MDT-SF21026-R4-FDR.pdf Markup Summary

Subject: Stormwater Comments Color
Page Index: 1
Date: 2/2/2022 2:18:07 PM
Author: dotprete
Color: ■
Layer:
Space:
Page Label: 1

NORTH POND NORTH FOREBAY  
SCALE: 1"=10'

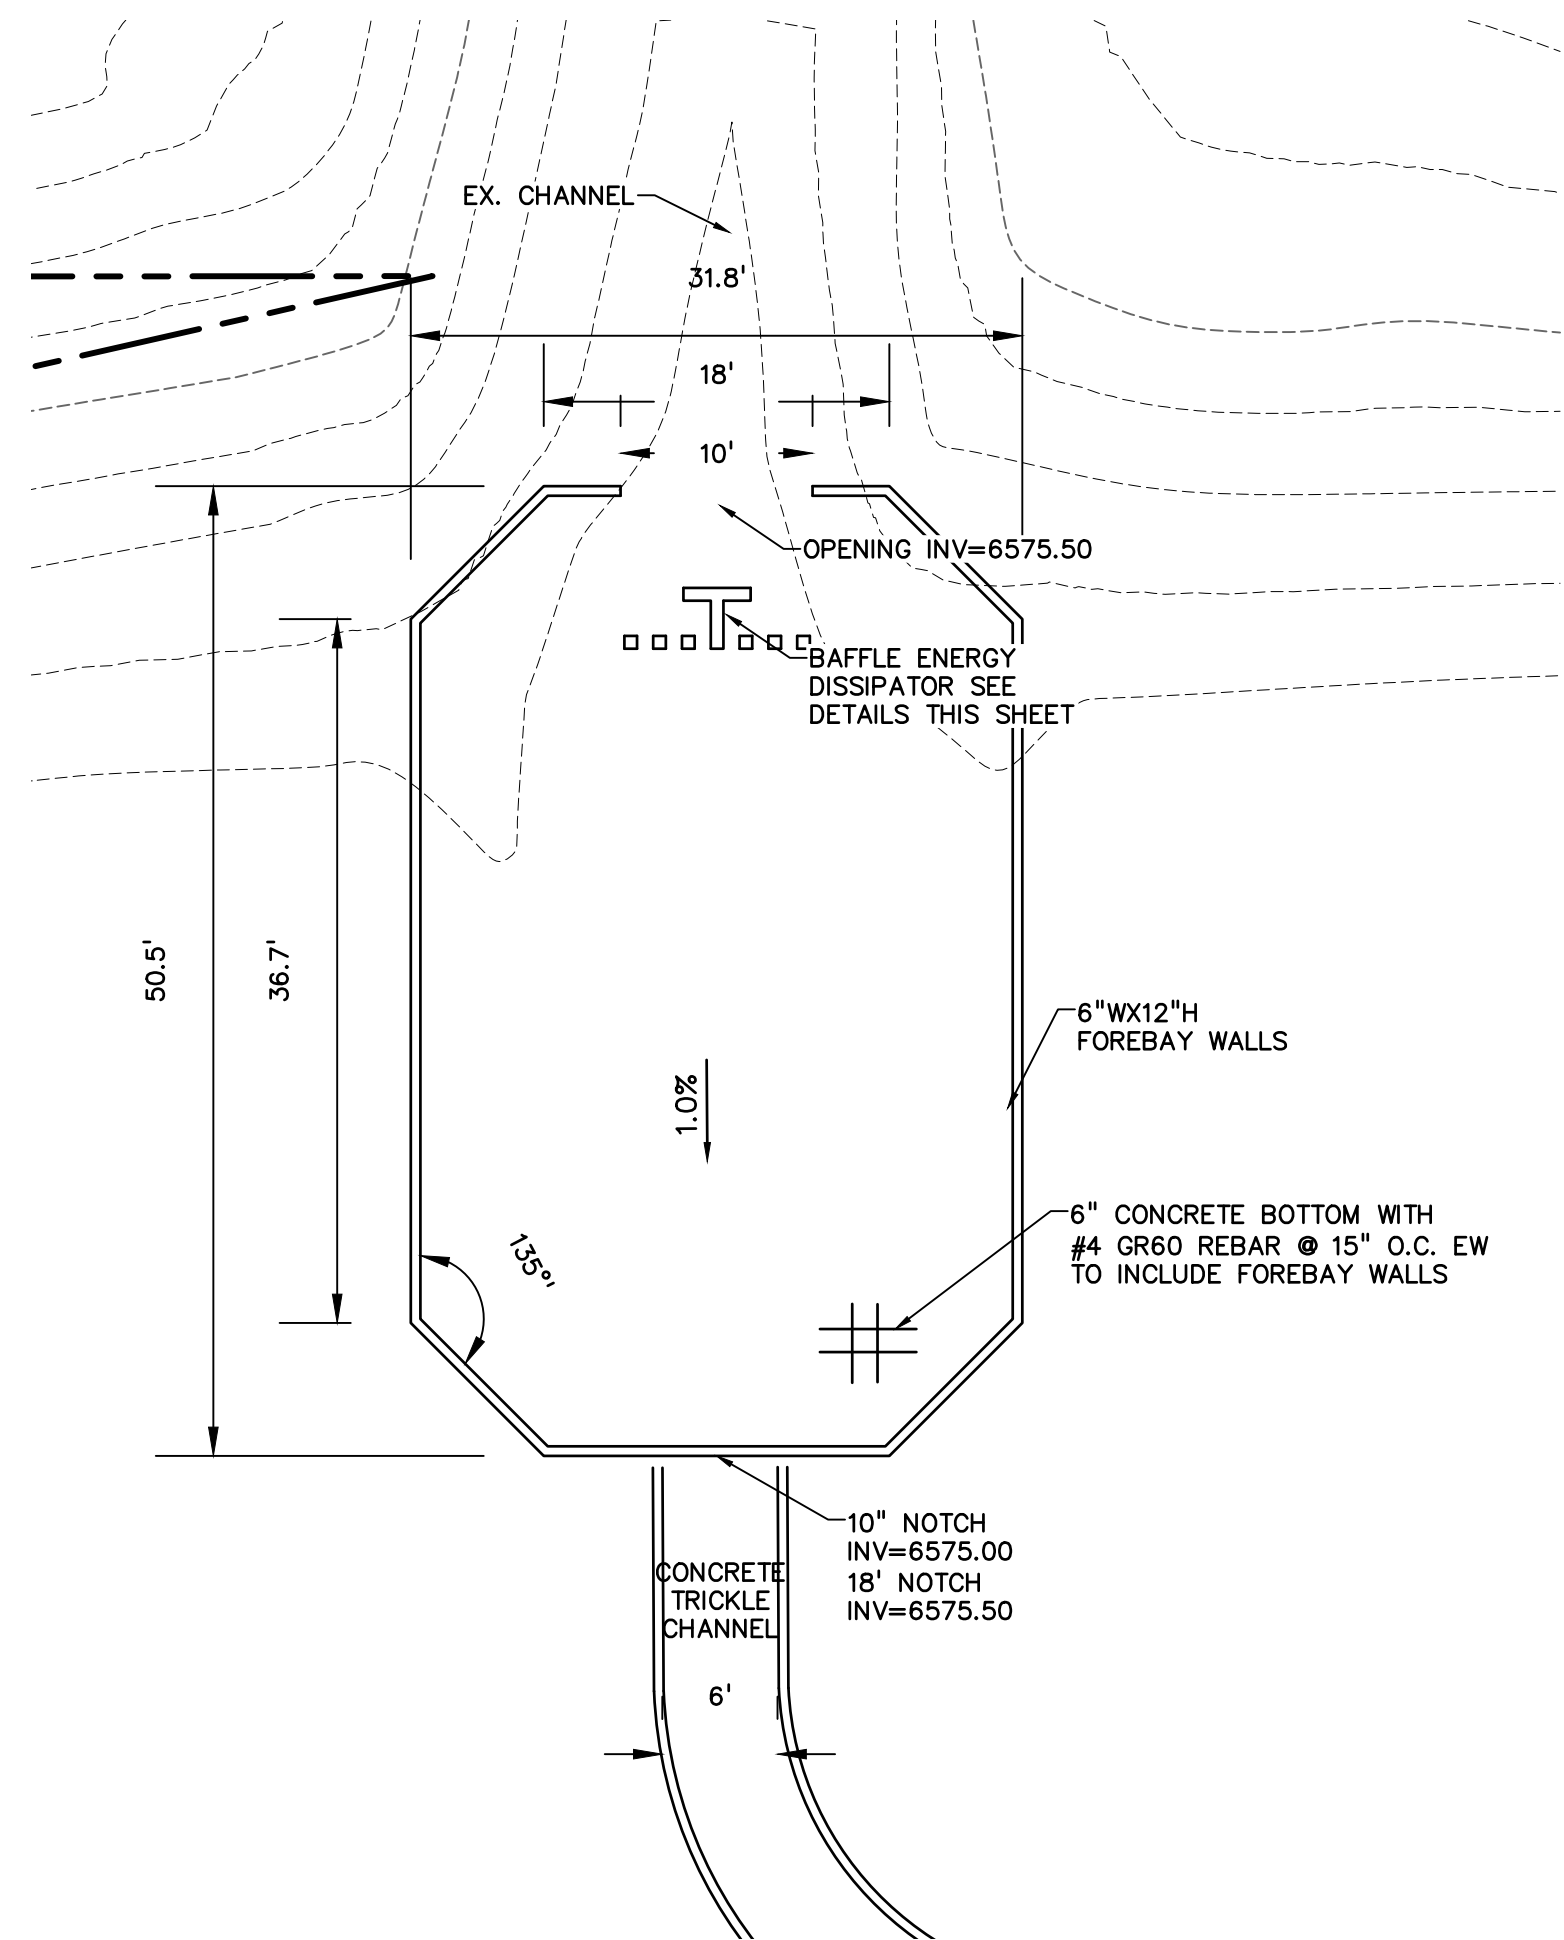
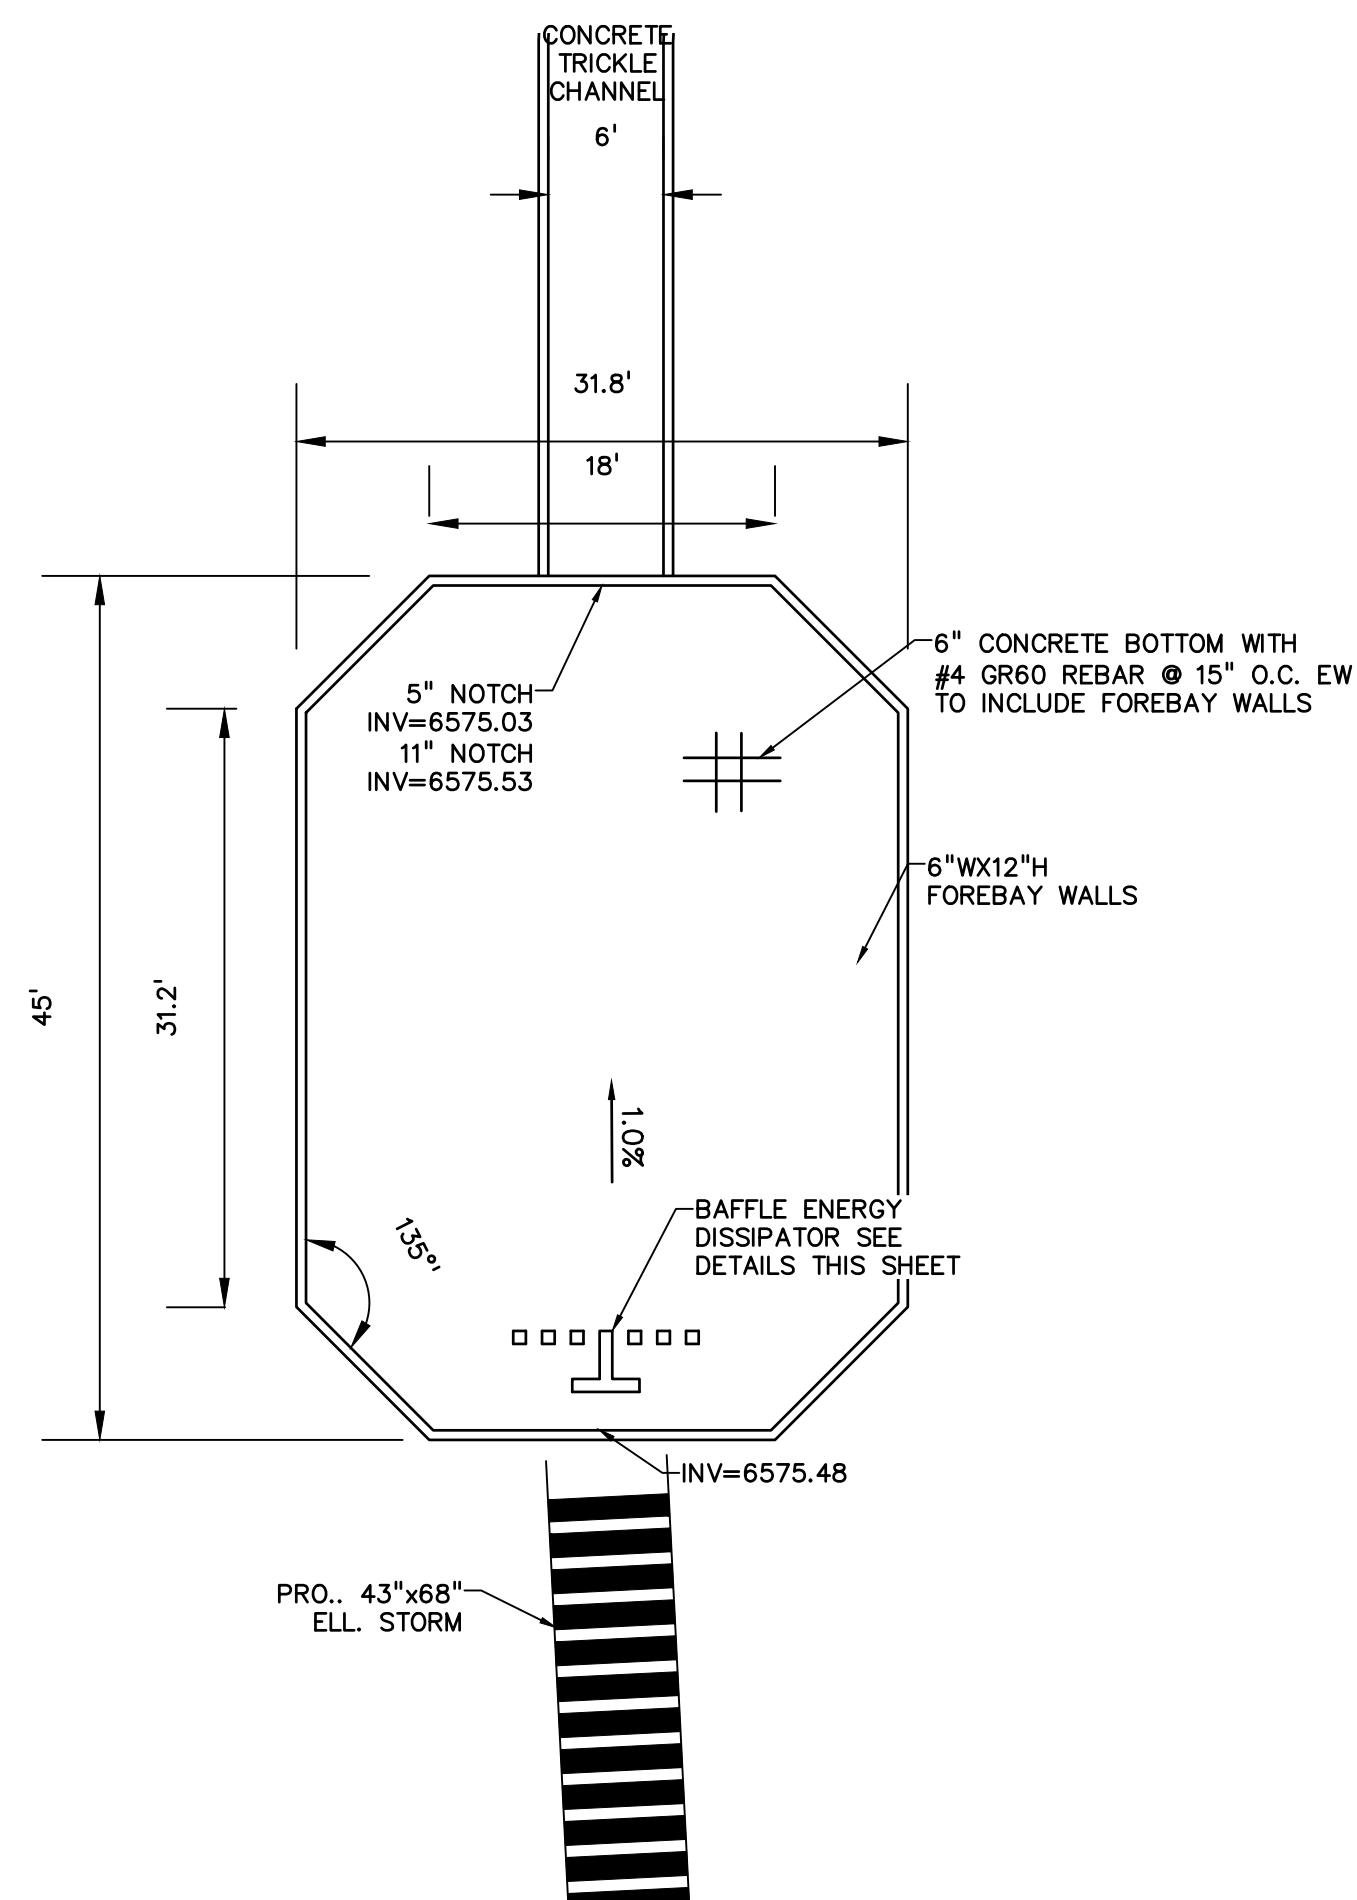
What is radius? Maintenance access needs to be within 25' of all forebays, outlets, etc.

How is access for maintenance being achieved for this forebay?
